Please can I raise the following comments in relation to the following applications by Newett Homes;

2023/92255 Land at Green Acres Close, Emley, Variation of Conditions 1 (Plans) , 2 (Crime Prevention) and 15 (Permitted Development) of Previous reserved matters approval 2021/93286 pursuant to outline permission 2020/91215

2023/92327 Land at Green Acres Close – modified plans for 6 Dwellings plus parking and landscaping and modified plans for ball stop netting.

2023/92255 and 2023/92327 – Plan modifications

Proposed Section 104 Plan (1:250)

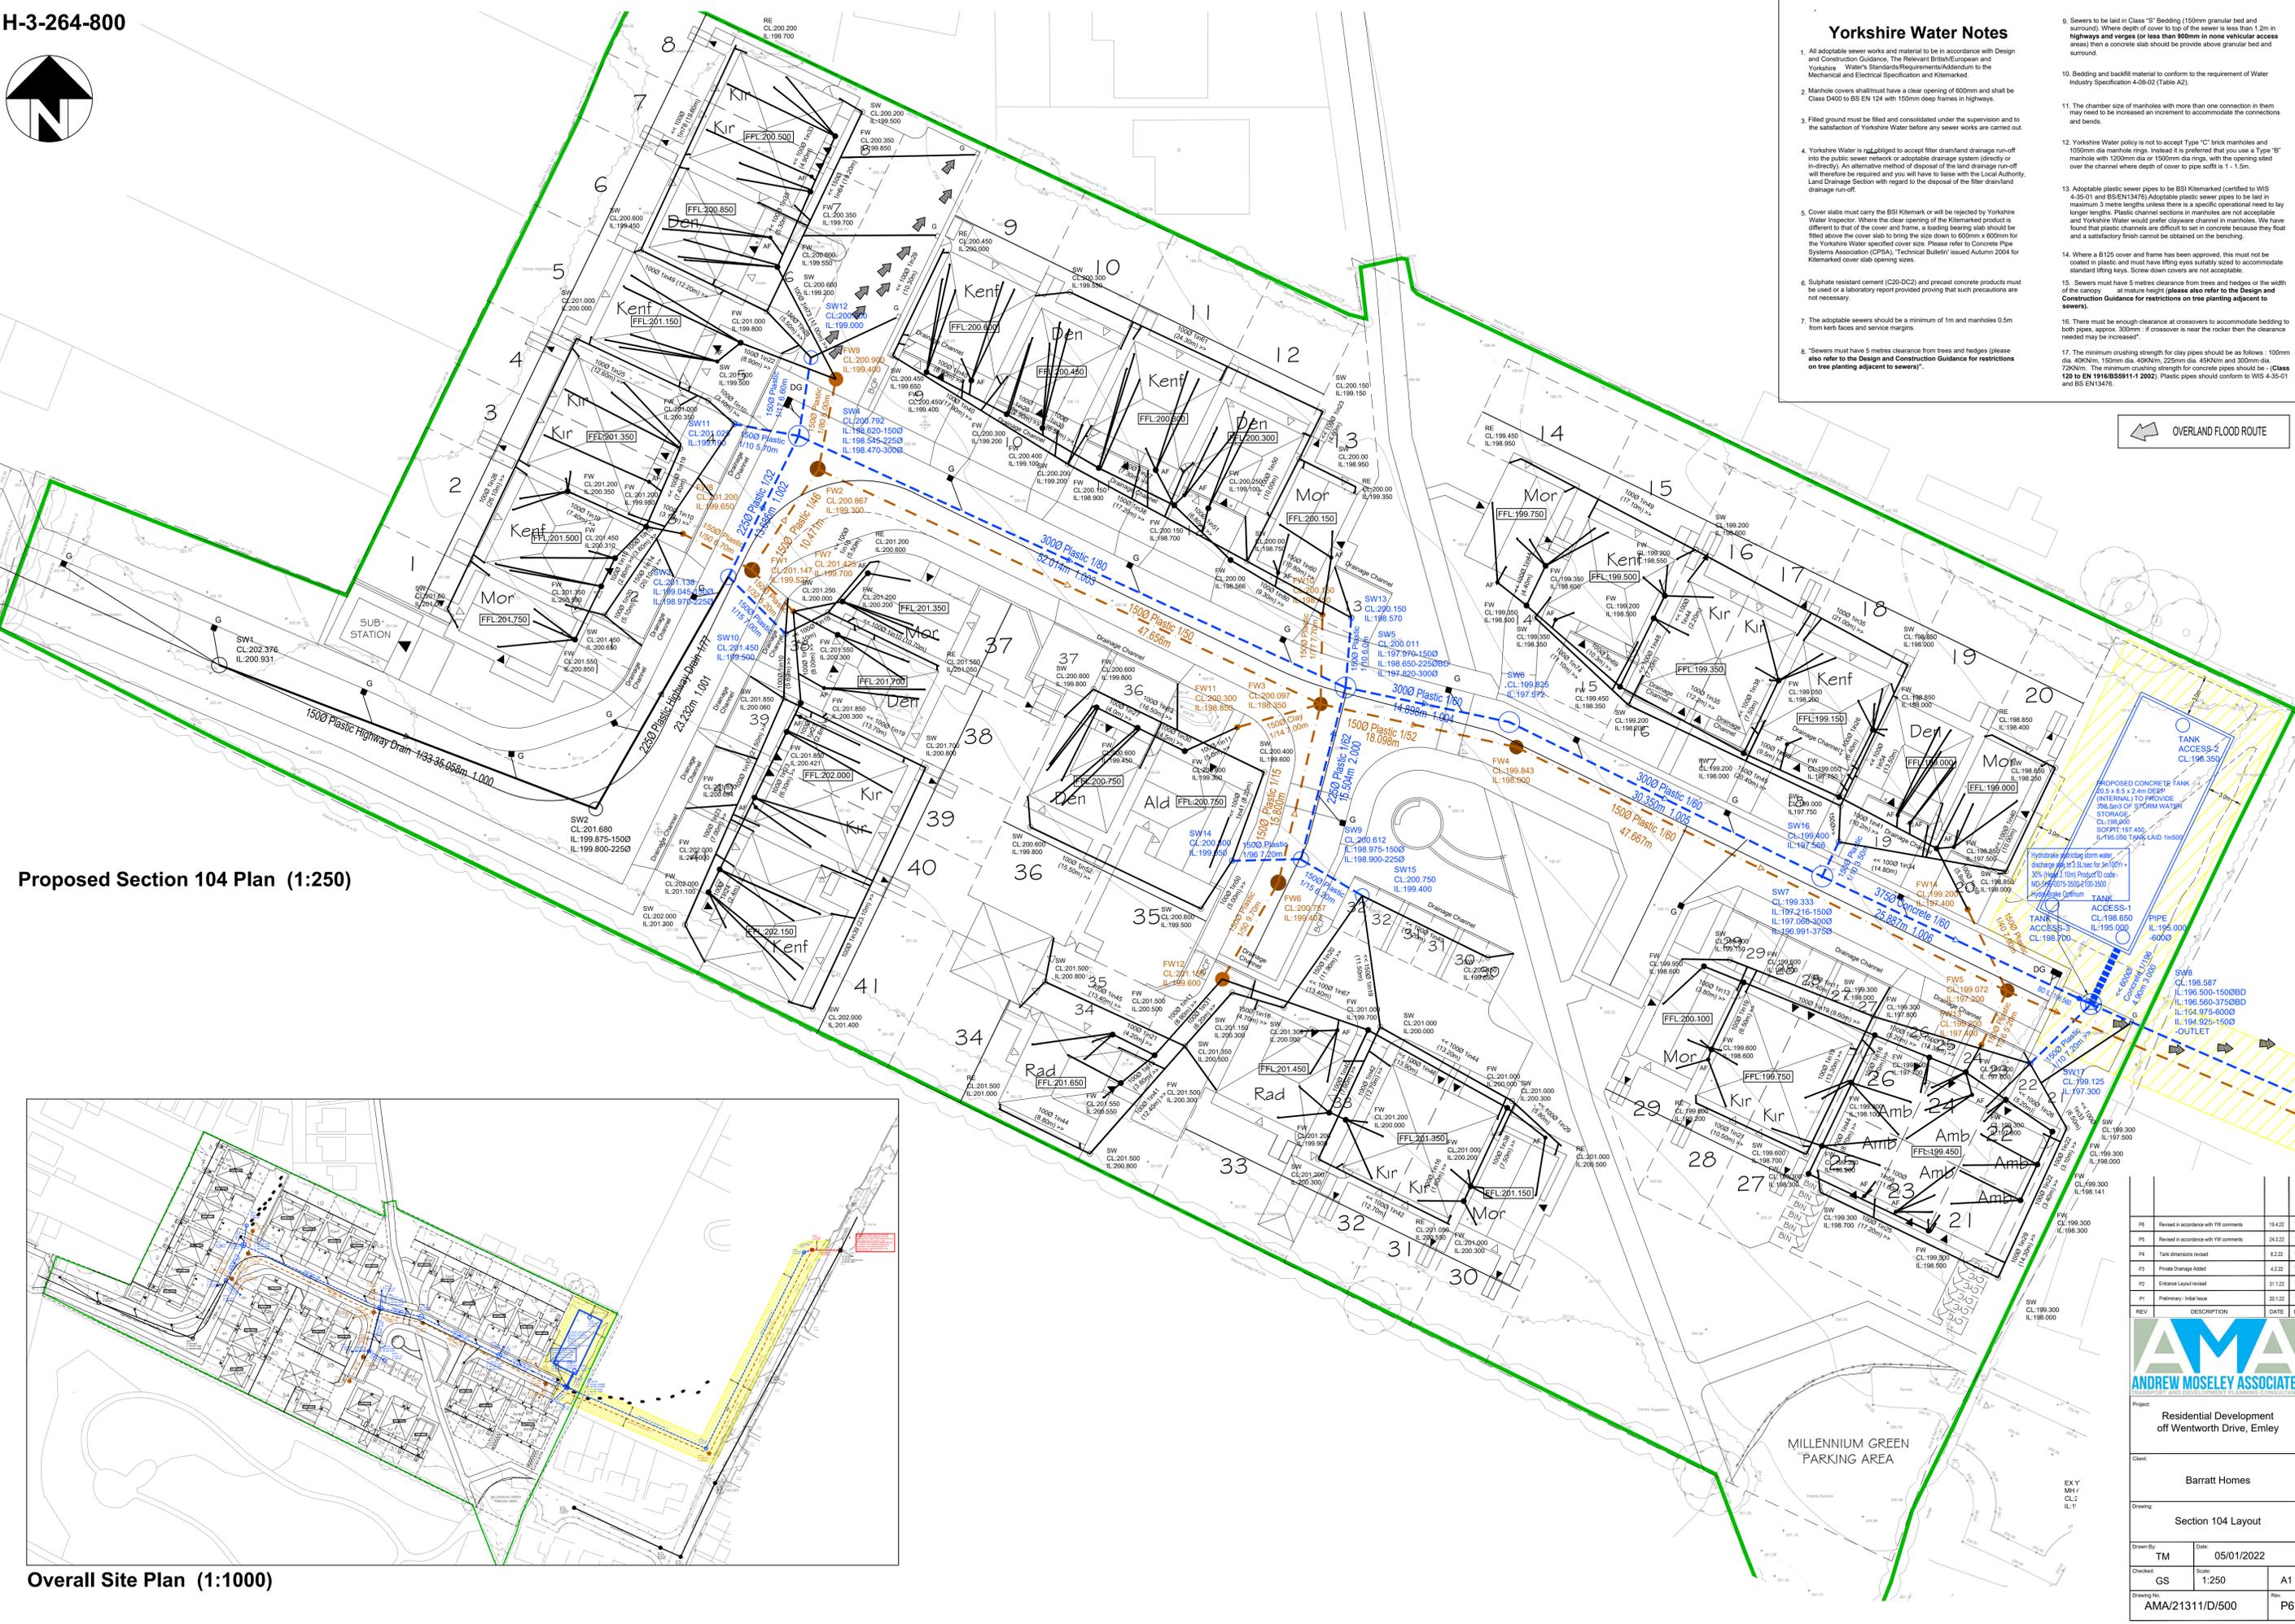
Newett Homes have submitted plans for temporary drainage that will affect the parking area and entrance to the Emley Millennium Green – Any drainage plans that affect the parking area or entrance must be discussed and agreed with the Trustees of the Green and must not block or impede the area at any time.
